PLANNING AMENDMENT

Application No. H08/0971/95

RE-BUILD ANNEXE TO FARM BUILDING
CONVERSION AFTER COLLAPSE.

Amendment: Fully weatherproofed link.
(drawing number RJ.11)

DRAWING No.:
RJ.11

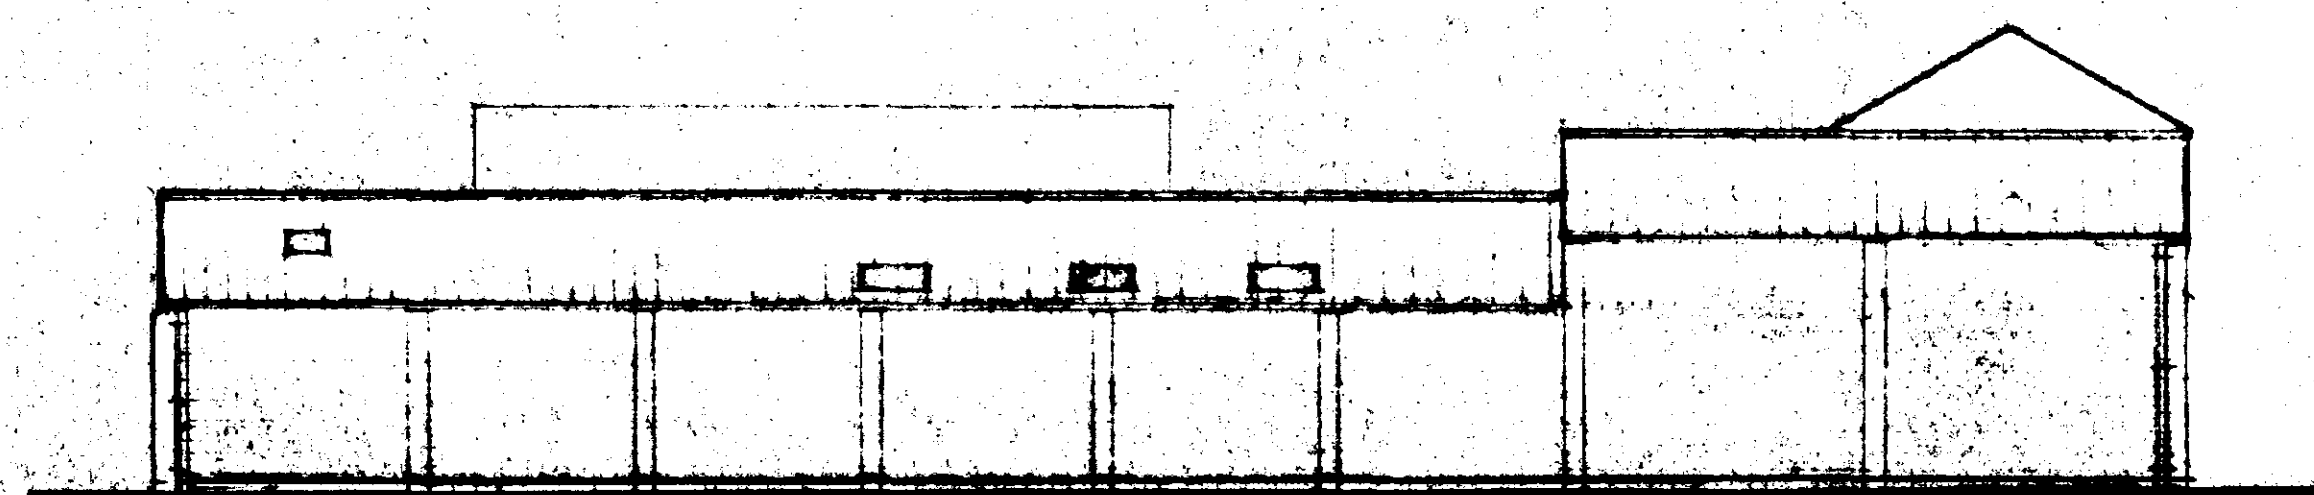
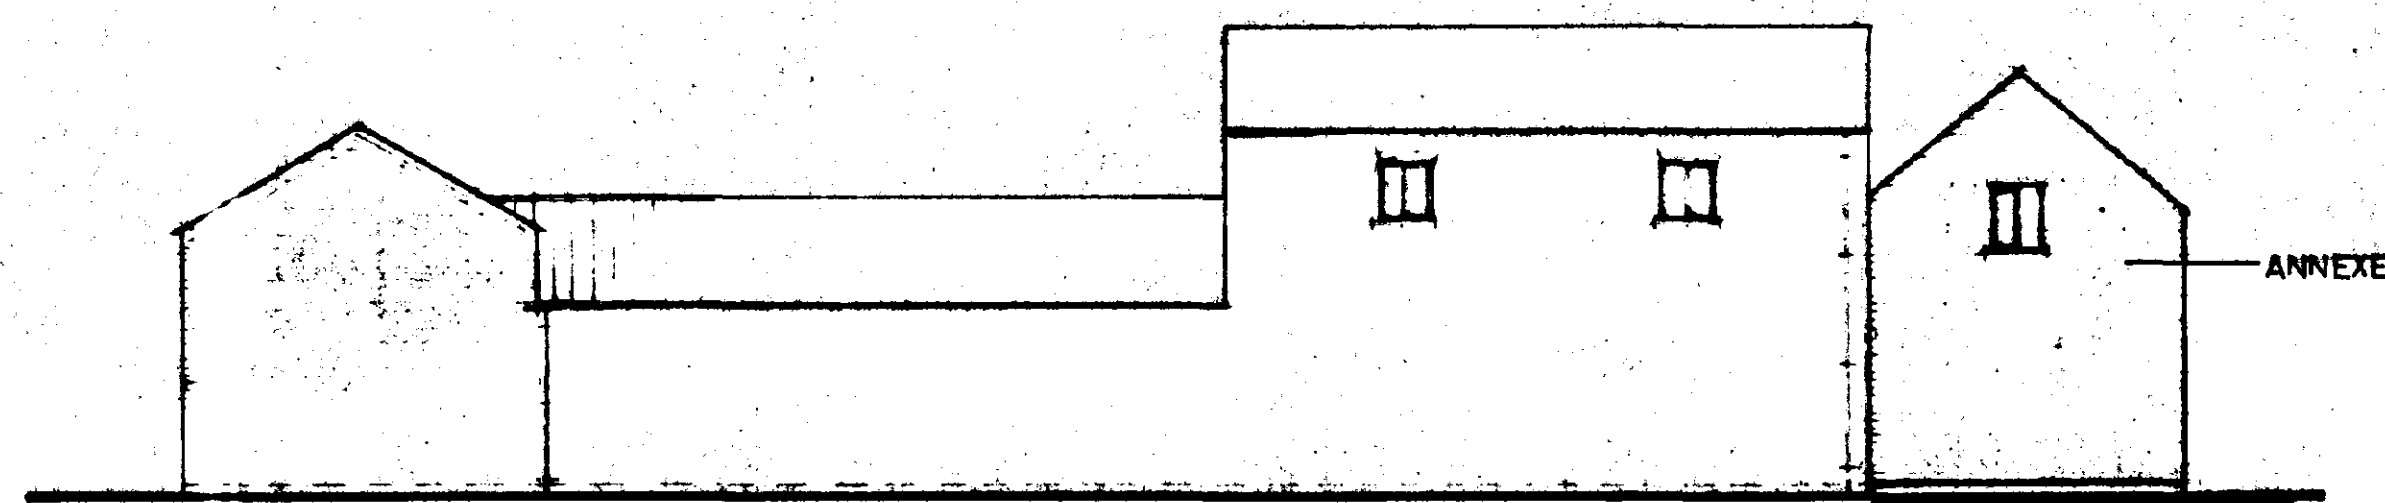
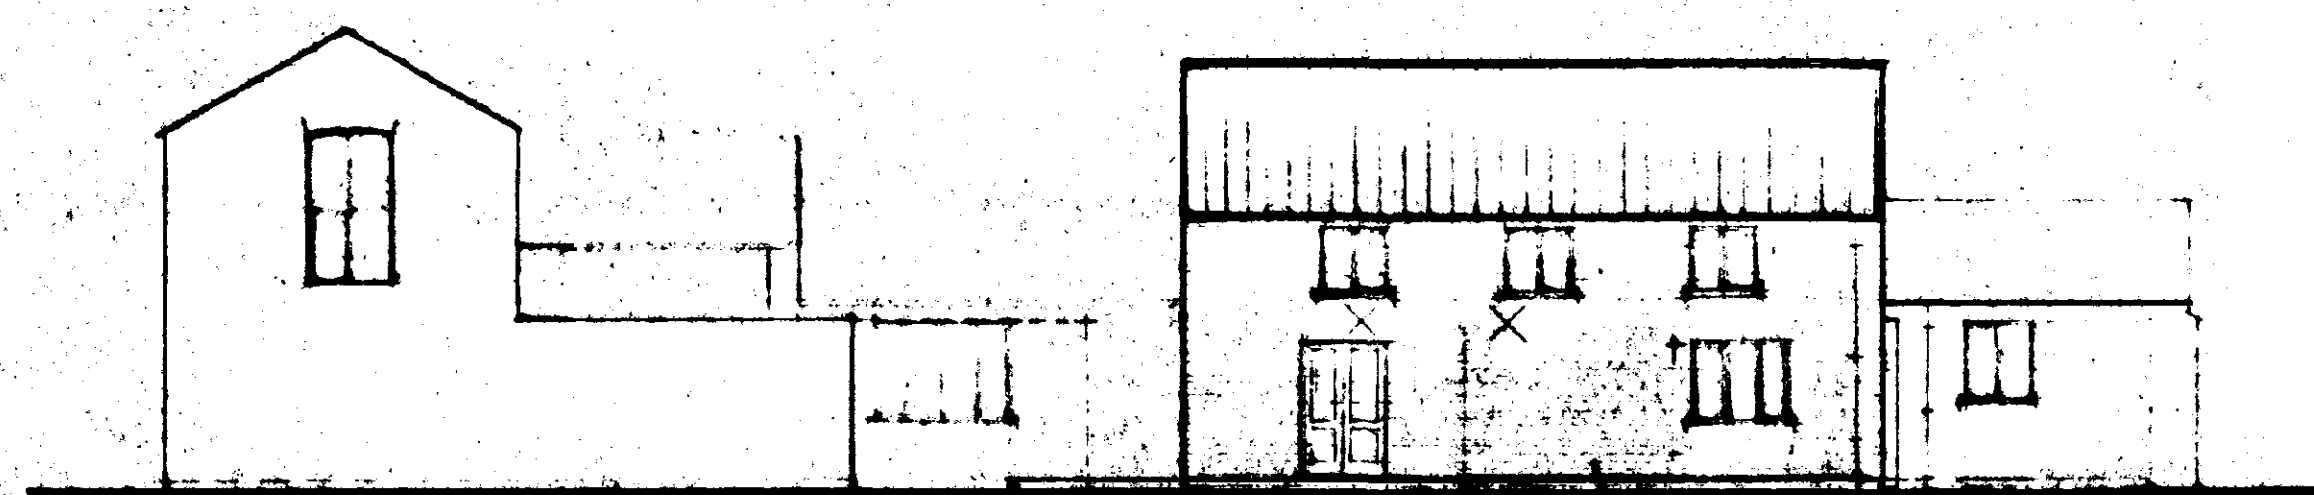
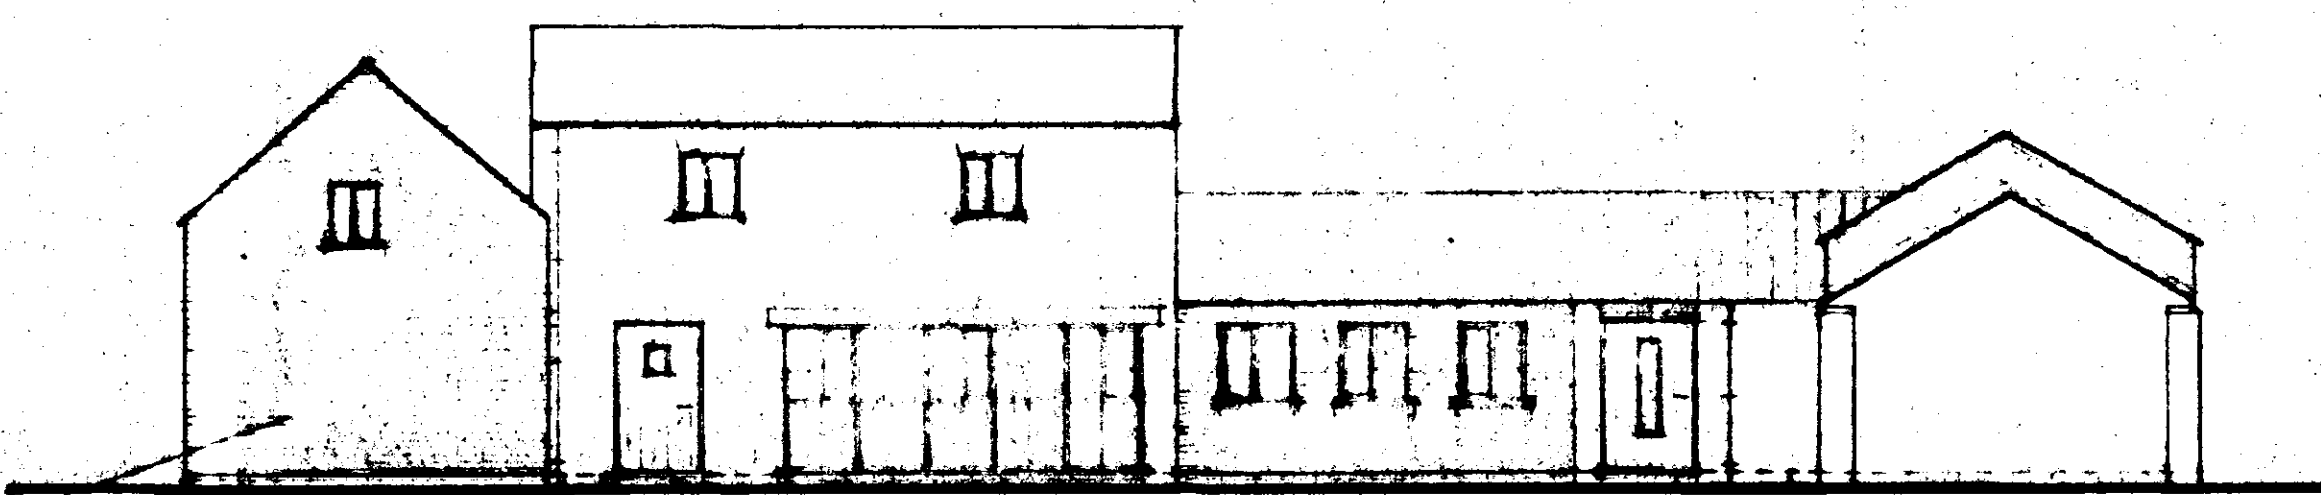
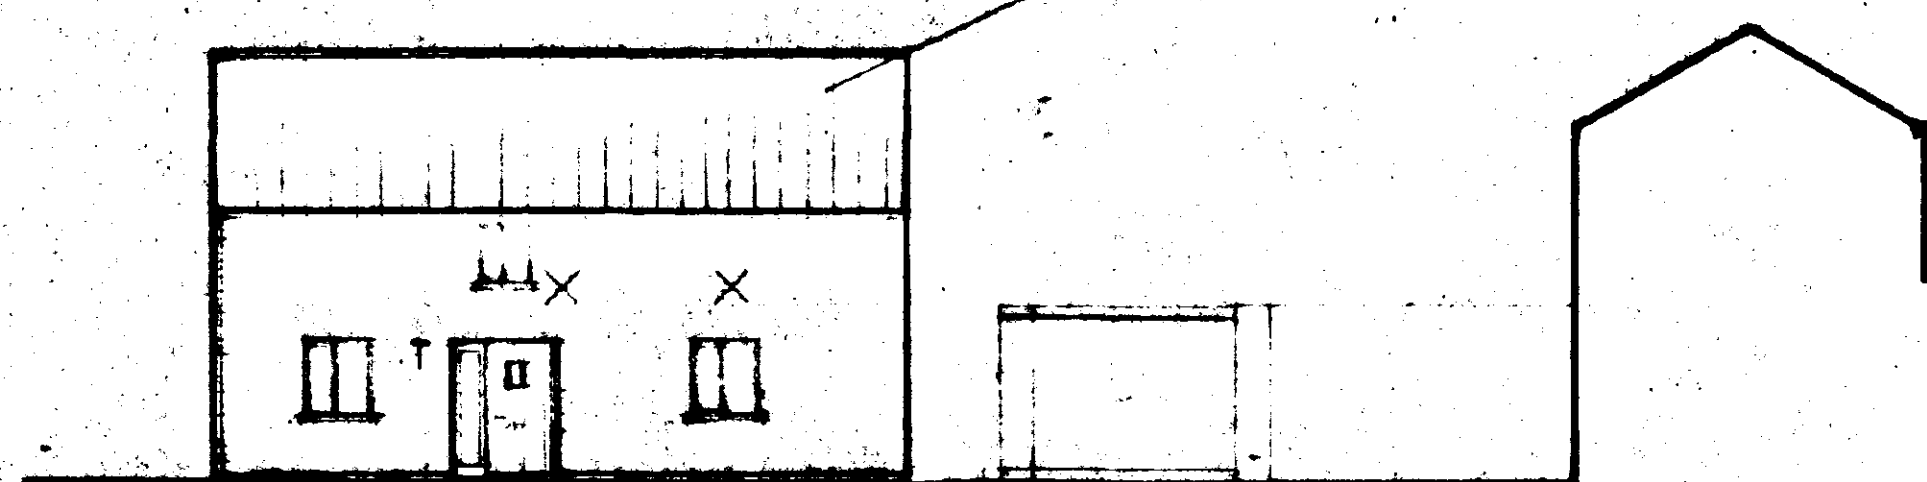
FULLY WEATHERPROOFED LINK.
